Our Ref: CM/18/19/PL
Your Ref:

17th April 2019

Town & Country Planning Act 1990 (as amended)
Town and Country Planning (Development Management Procedure) (England) Order 2015
Application for Planning Permission

Development Erection of 2 No 3 bed dwellings with off-road parking and associated landscaping
Location Land at Entrance to Waterford Gardens Horsemere Green Lane Climping

drawing title:
Site Plan

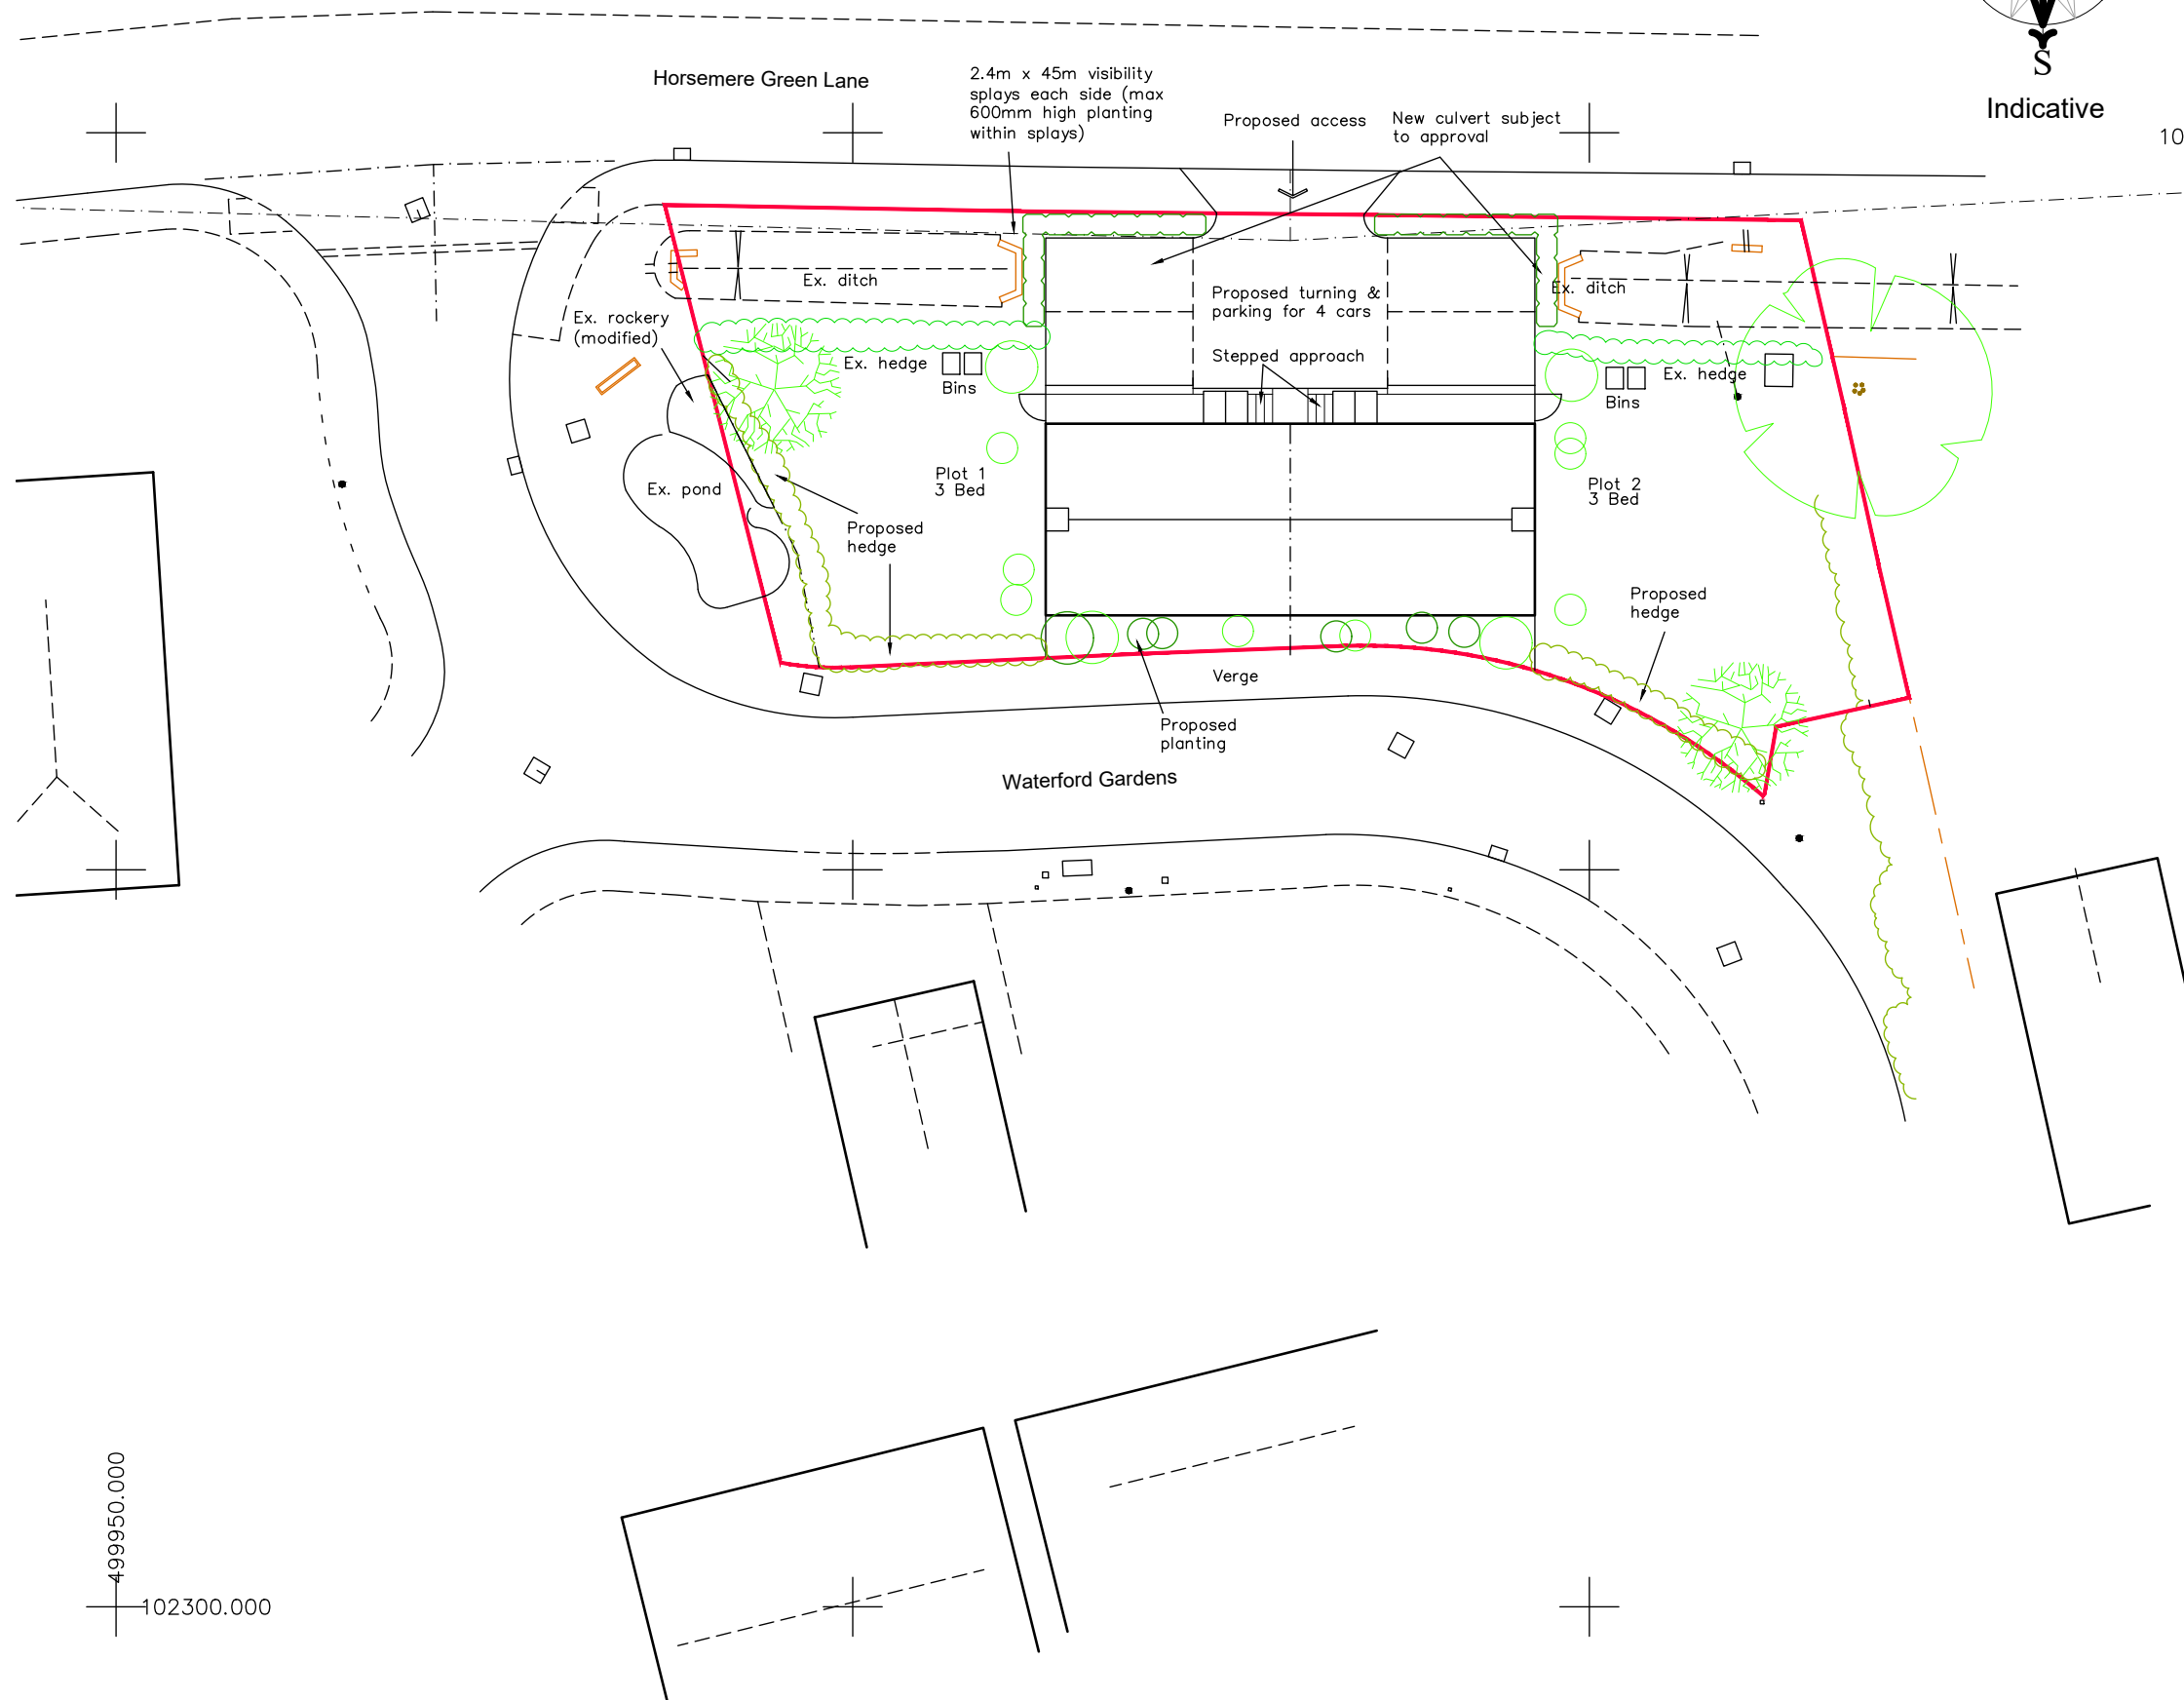
Block Plan

Please submit 1 electronic or 3 paper copies of a block/site plan which includes all the dimensions from the individual properties to their individual site boundaries.
